Ref: 4425 Plan report Rev A

Benjamin Kavich v Garry Holt; Matthew Bartolo
Land and Environment Court of New South Wales Proceedings No. 87523 of 2020
50 Peter Brock Drive, Eastern Creek

Review of Sec 4.55 Application S29/3/97- Mod -1

May 18, 2020 - 16:52pm X:\Projects\141425 Eastern Creek\Drawings\01a1.dwg\141425DT01a1.dwg

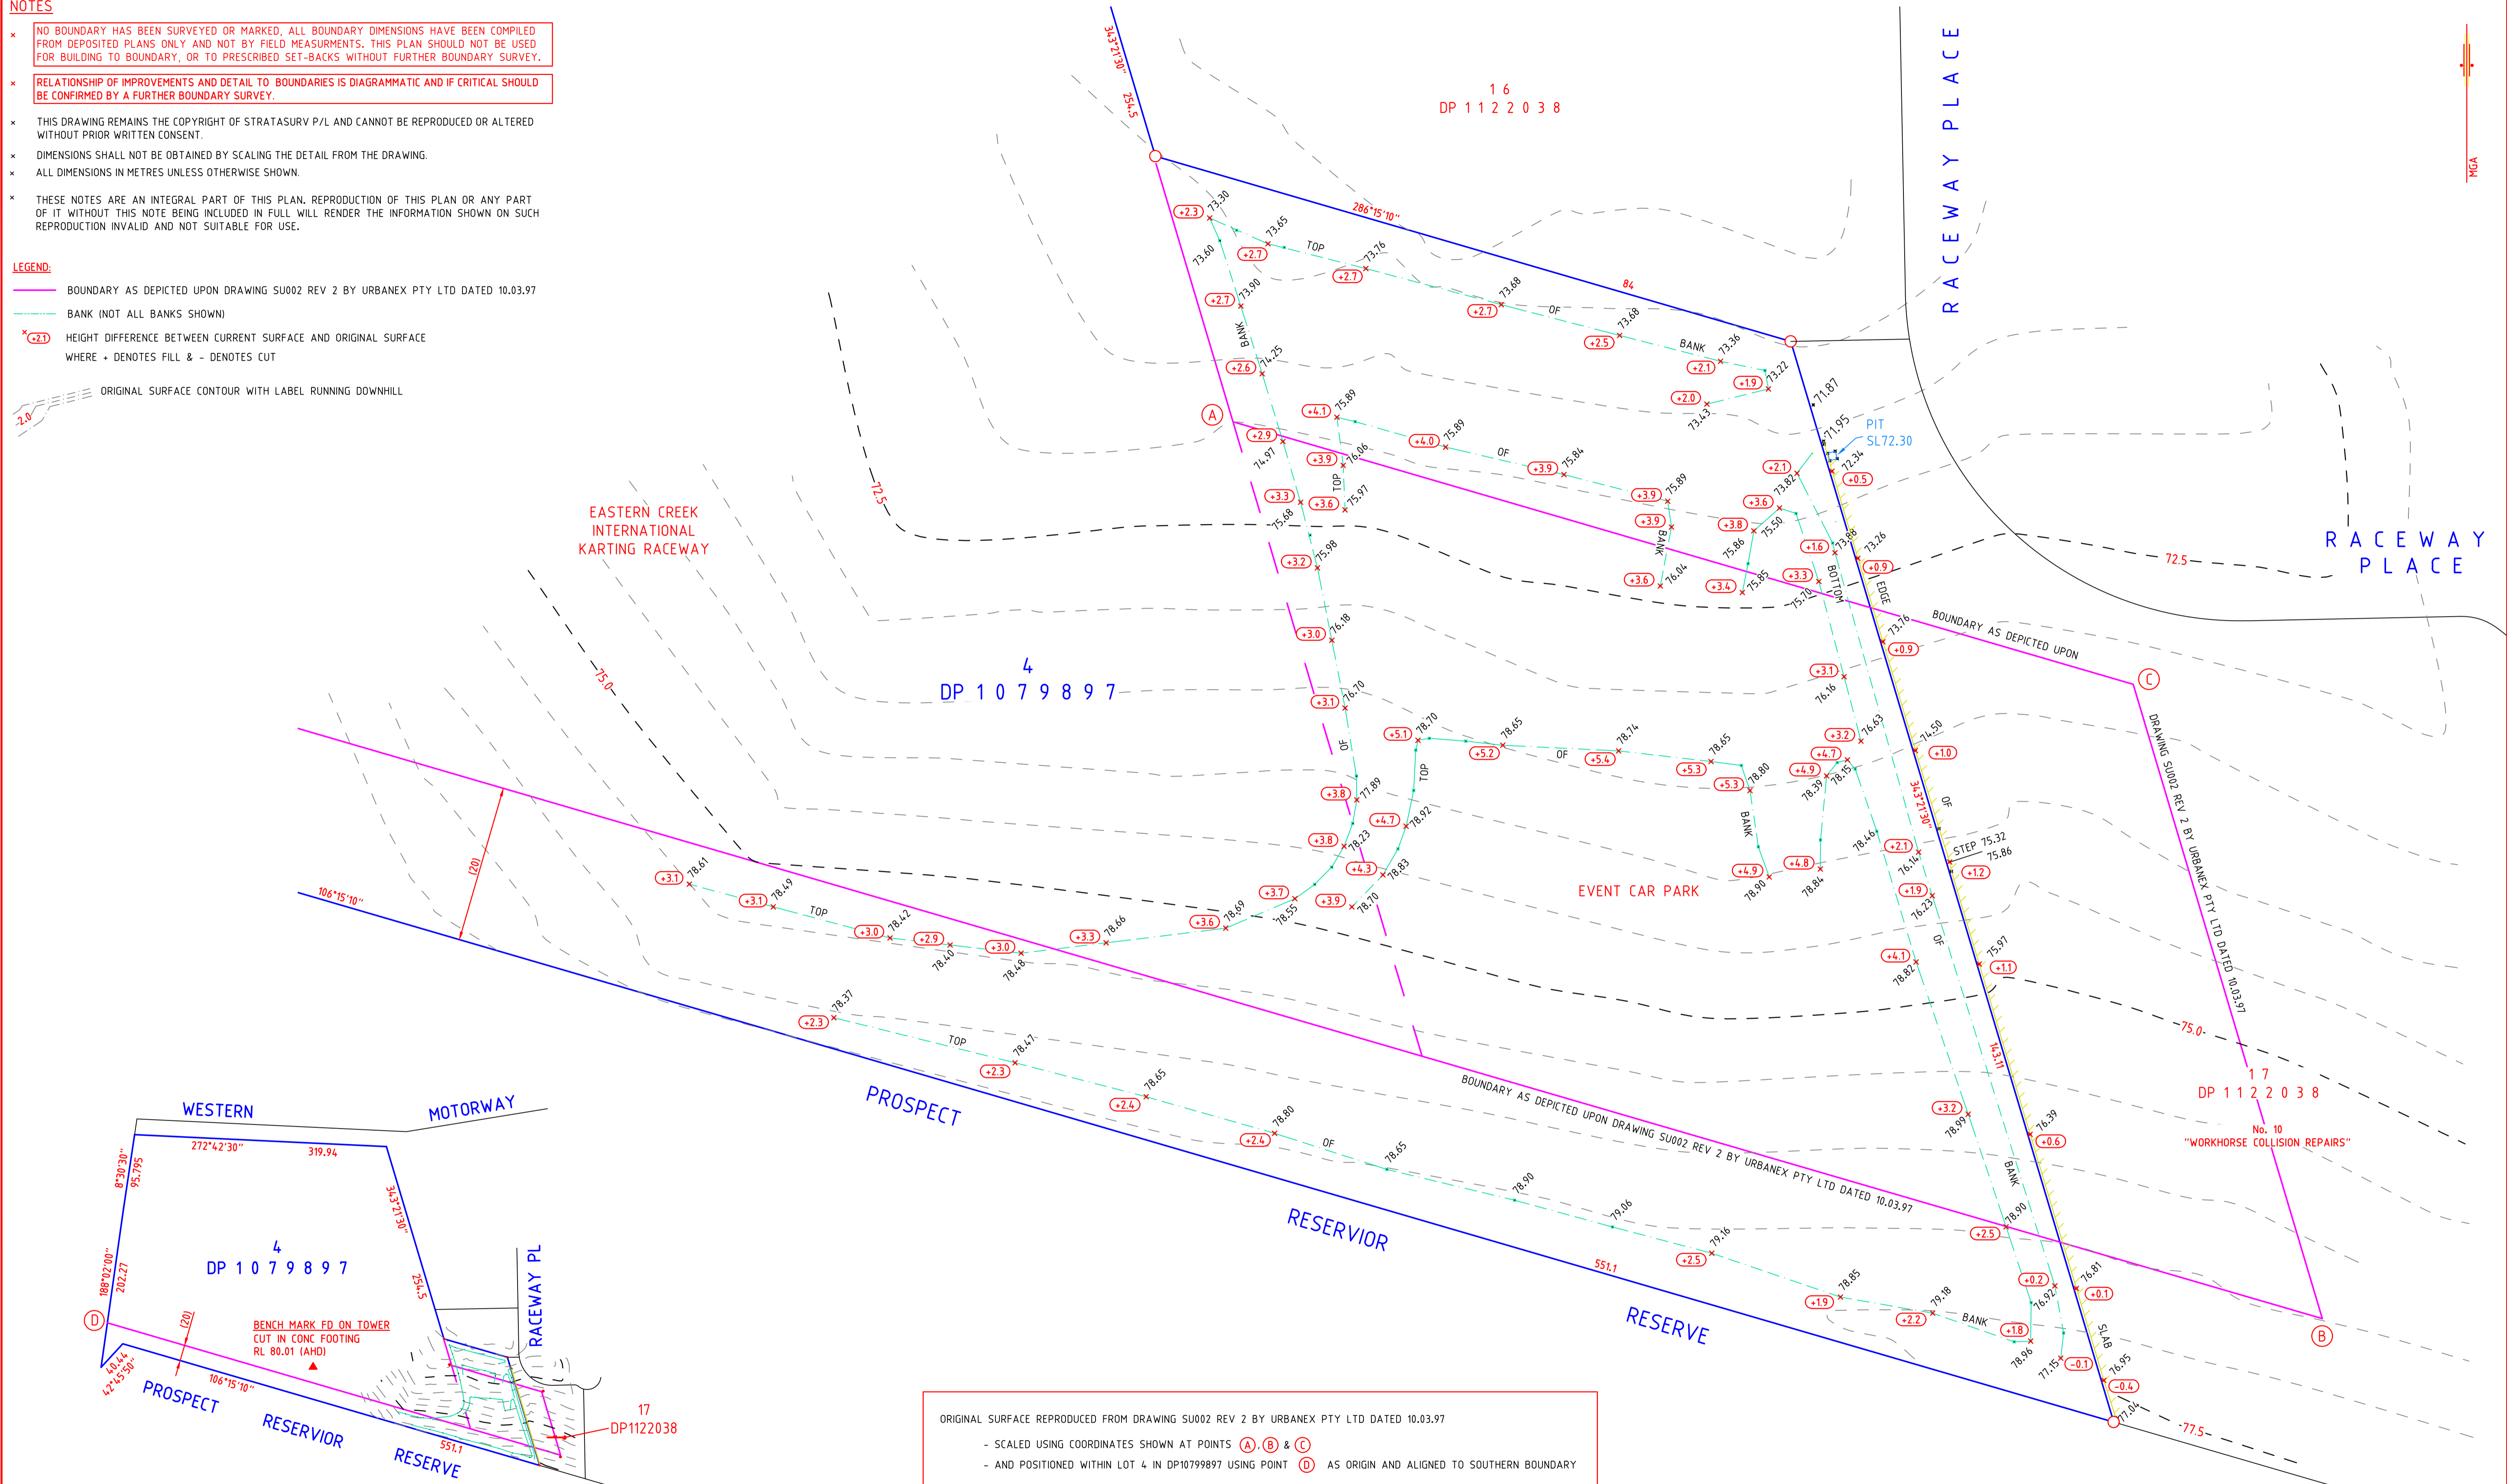
The levels of the site were surveyed by StrataSurv in May 2020 and my expert report confirmed that the differences in level between the DA approved Urbanex survey 1997 and the StrataSurv survey of 2020 were upto **5.4 metres higher** . See attached StrataSurv plan May 2020 annexure B

The StrataSurv 2020 surveyed surface was typically a minimum of 2 metres higher than the Urbanex 1997 survey with the only area of surface that appeared not to have changed in height being the small area at the south eastern corner of the land surveyed. At this location the surface in fact was 0.1 metre lower than the Urbanex 1997 surveyed surface.
